City of Portland, Maine - Building or Use Permit Application

Permit No: 2012-65702	Issue Date:	CBL: 030 A001001
--------------------------	-------------	---------------------

Proposed Use: Commercial - Restaurant - 1st & 2nd floors - Poppy's Fish Shack & Oyster Room	Proposed Project Description: Interior renovations for new restaurant 1st & 2nd floors (change of use for 2nd floor), including structural upgrades to beams, columns & wharf bents and 2nd floor exterior deck w/outside dining on both decks (internal demo permit #2012-10-5242)
--	--

Dept: Building **Status:** Approved w/Conditions **Reviewer:** Jeanie Bourke **Approval Date:** 02/08/2013

SECTION 2
 1 1/2" = 1'-0"

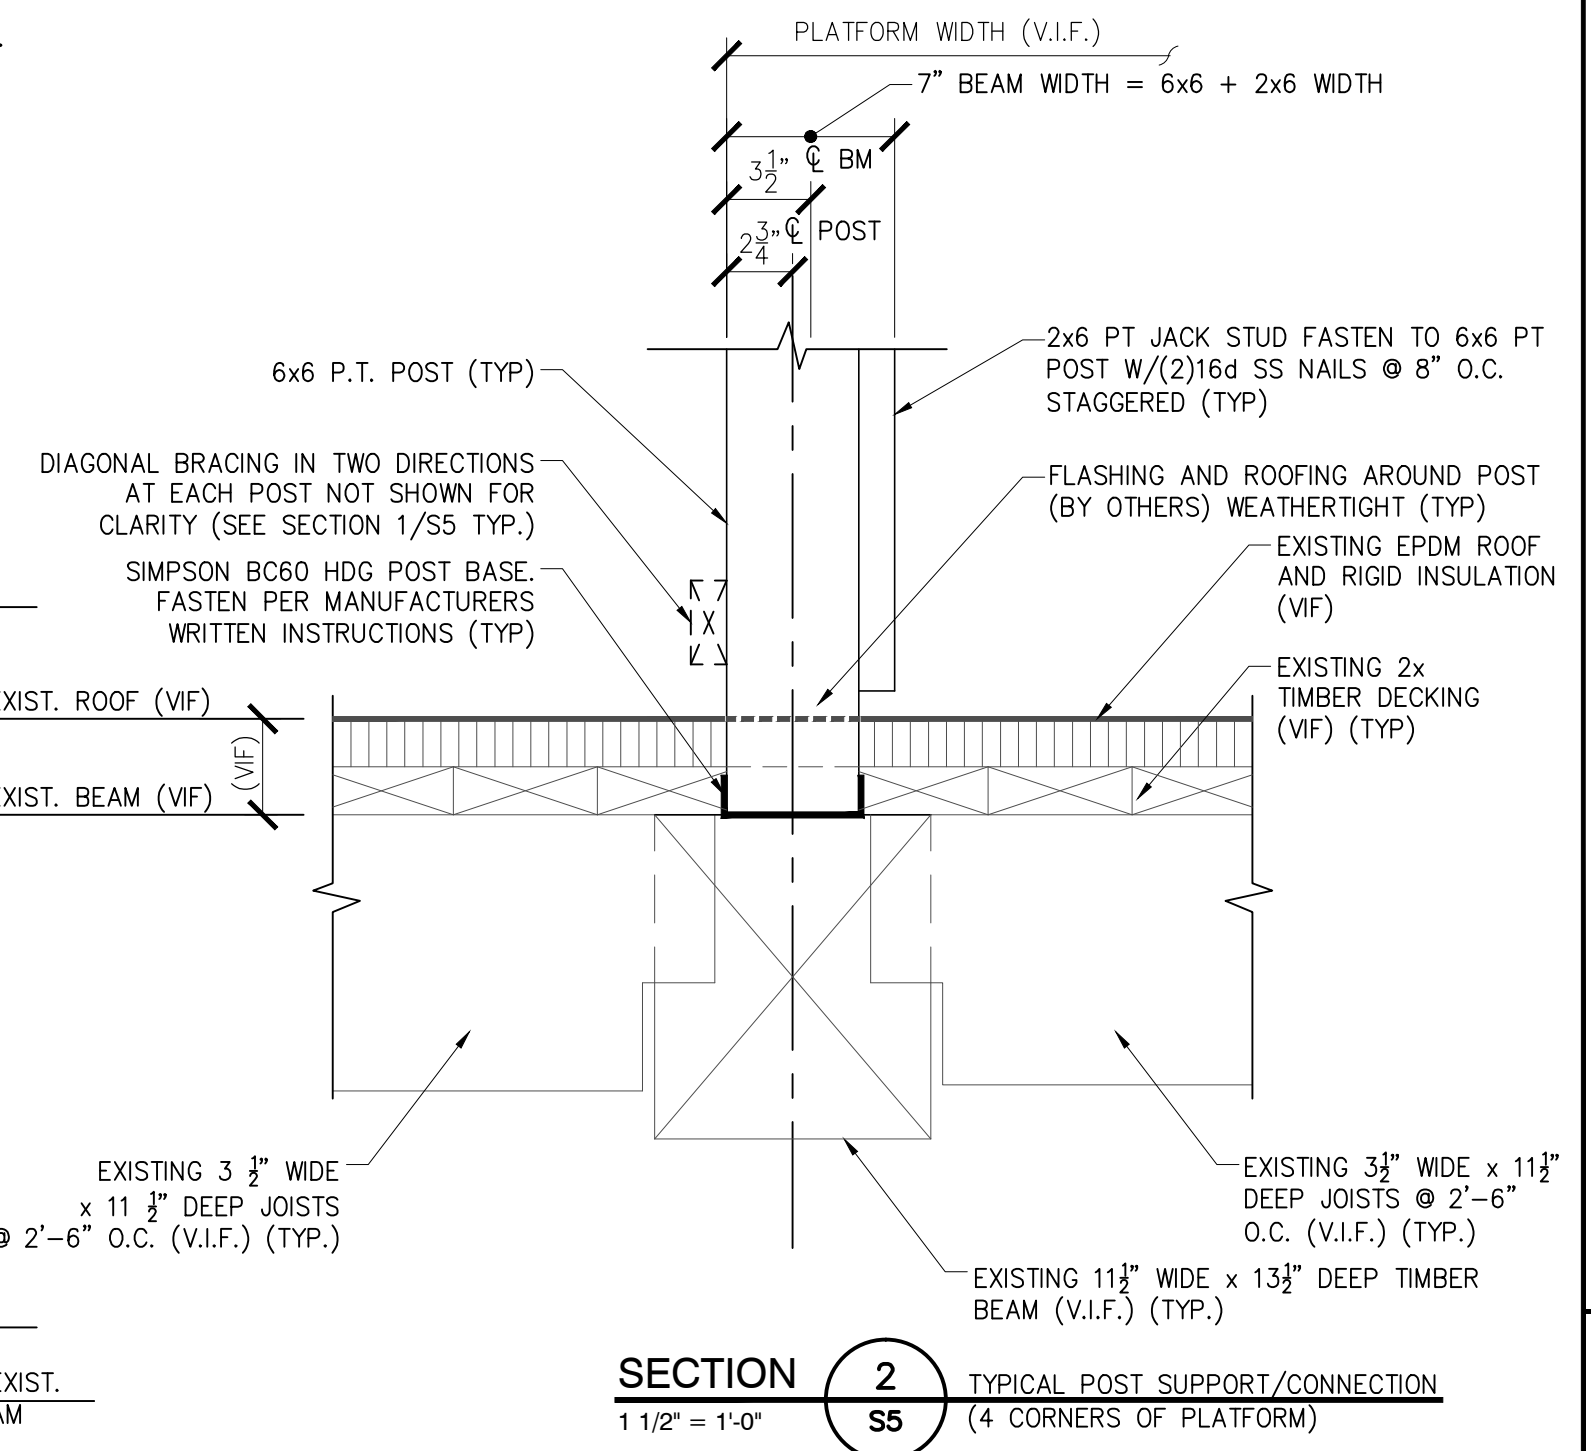
- 11) Framing/structural details for the rooftop platform for the HVAC equipment shall be submitted for review prior to commencement of this work.

4/24/13 See Structural plan S5 for Rooftop Platform
Construction - HVAC equip. JWB
